WEST SUSSEX COUNTY COUNCIL CONSULTATION

TO:	Arun District Council FAO: Anita Gardner
FROM:	Stephen Gee WSCC - Highways Authority
DATE:	25 August 2021
LOCATION:	Land west of Brook Lane and South of A259 Angmering BN16 3JL
SUBJECT:	A/26/21/RES Approval of reserved matters following outline consent A/44/17/OUT for appearance, landscaping, layout & scale for the demolition of existing buildings on site & erection of a mixed use development comprising of 90 No. residential dwellings & a care home & ancillary facilities including railway crossing together with associated access, car parking & landscaping. This application also lies within the parishes of Rustington & Littlehampton. Various substitute plans and documents received.
DATE OF SITE VISIT:	n/a
RECOMMENDATION:	More Information
S106 CONTRIBUTION TOTAL:	n/a

Hard Landscape Proposals

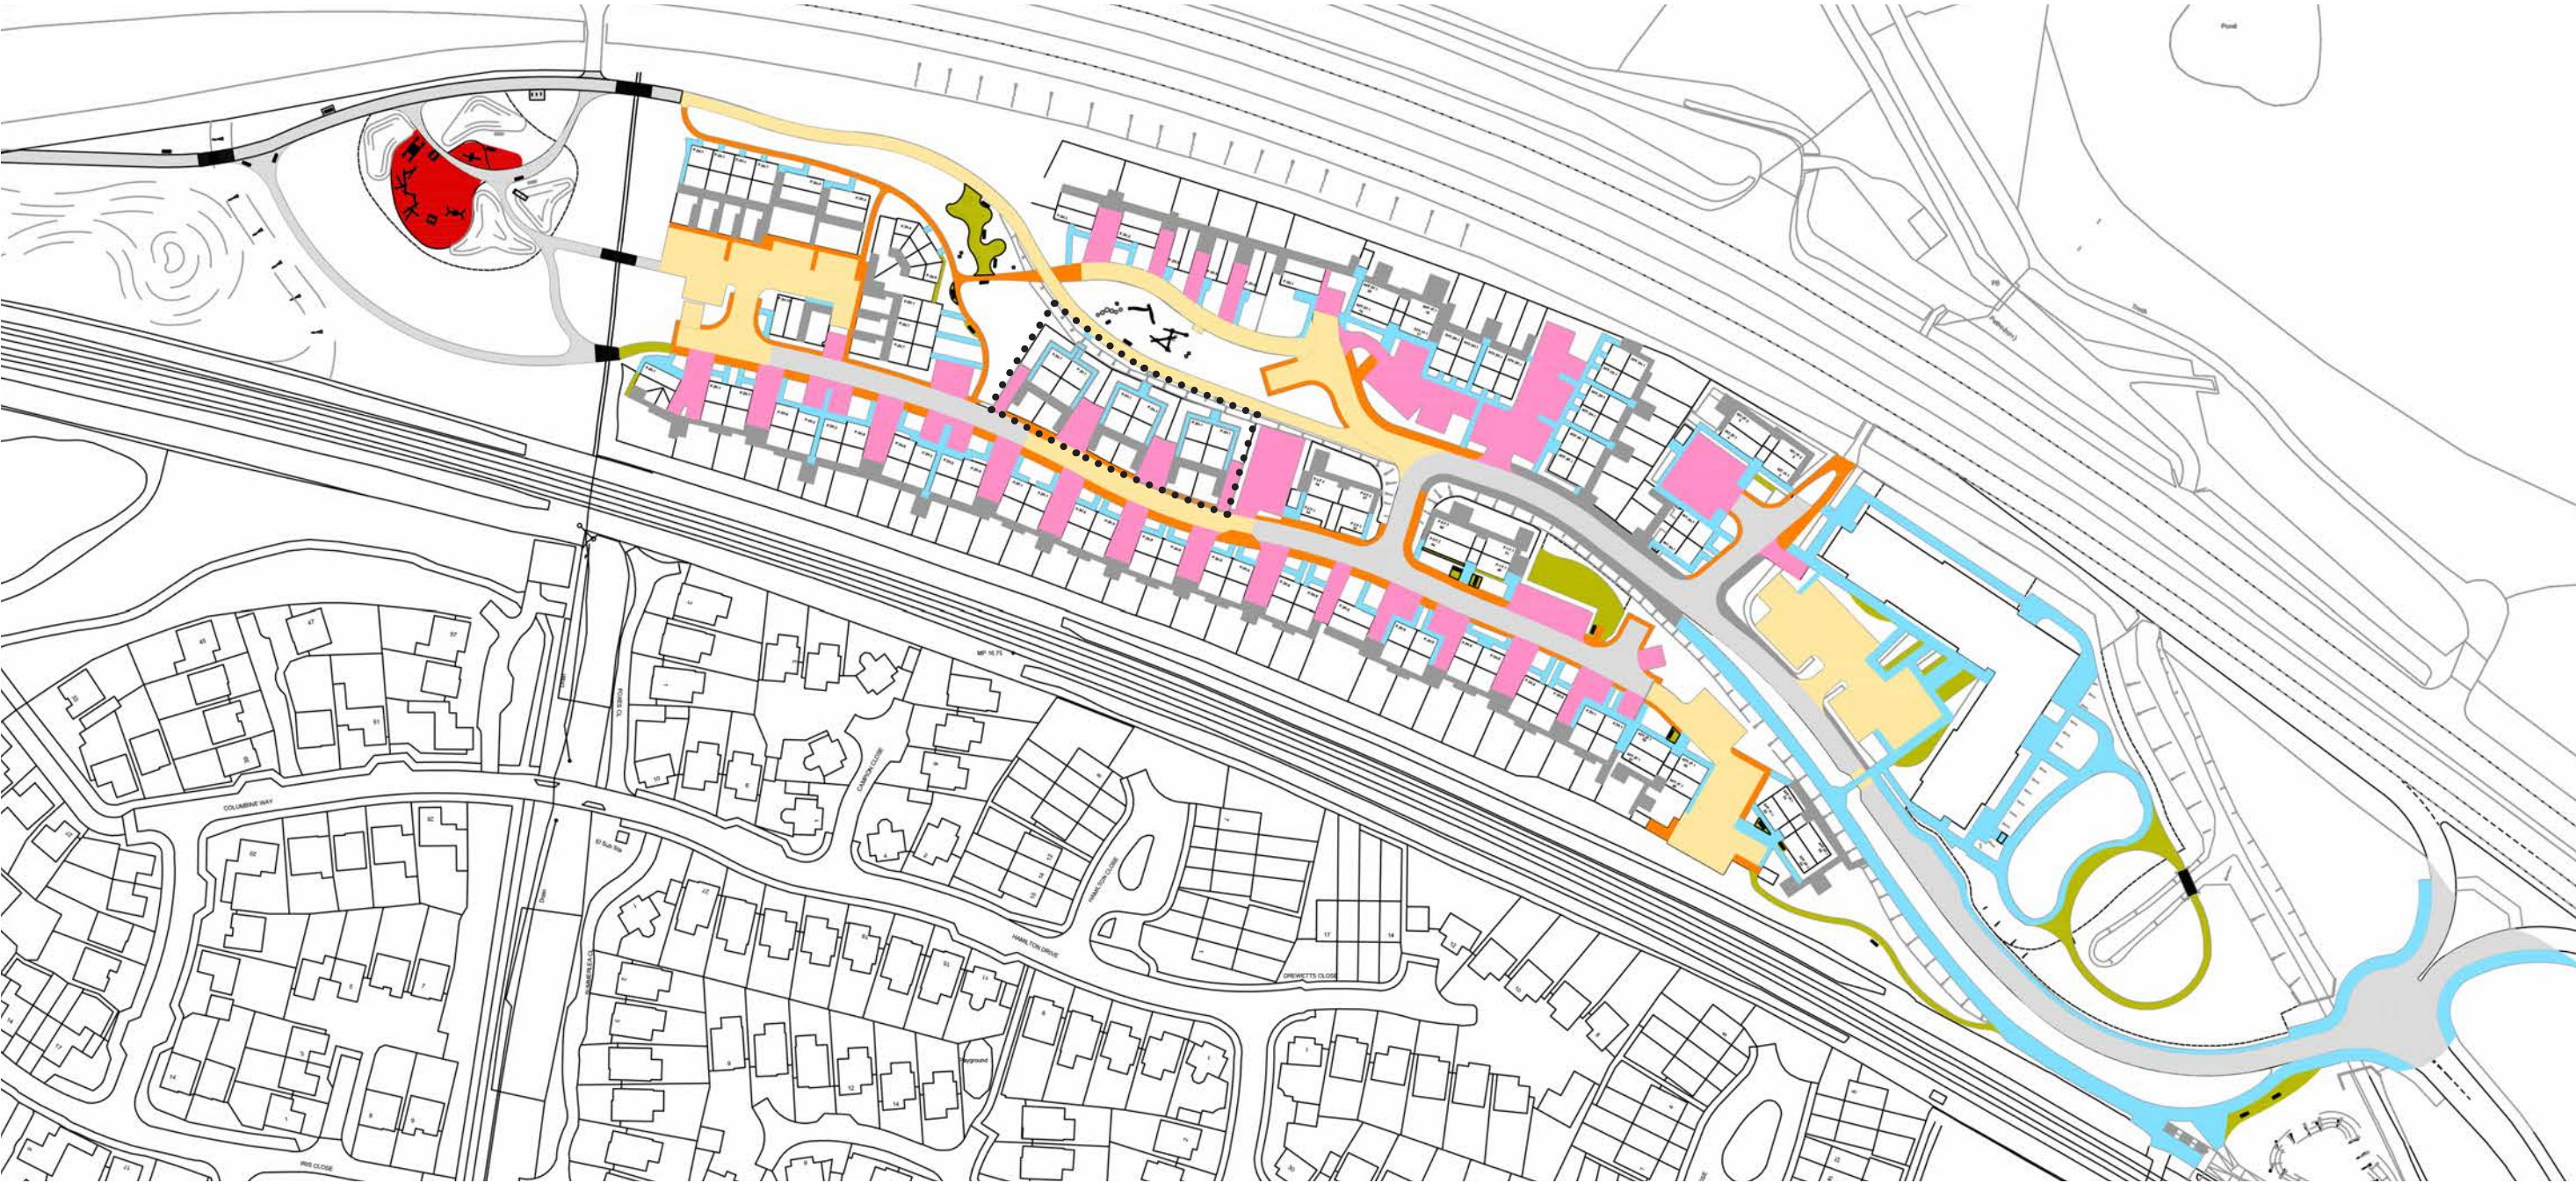
The applicant has provided justification for cyclists to share the carriageway with motor vehicles however no details are provided to the west of the site are provided (e.g permissive permission adjacent to the PROW)

A parking plan including the identification of vistor parking spaces should be provided. Further details on cyclist provision in the western area of the site should be provided.
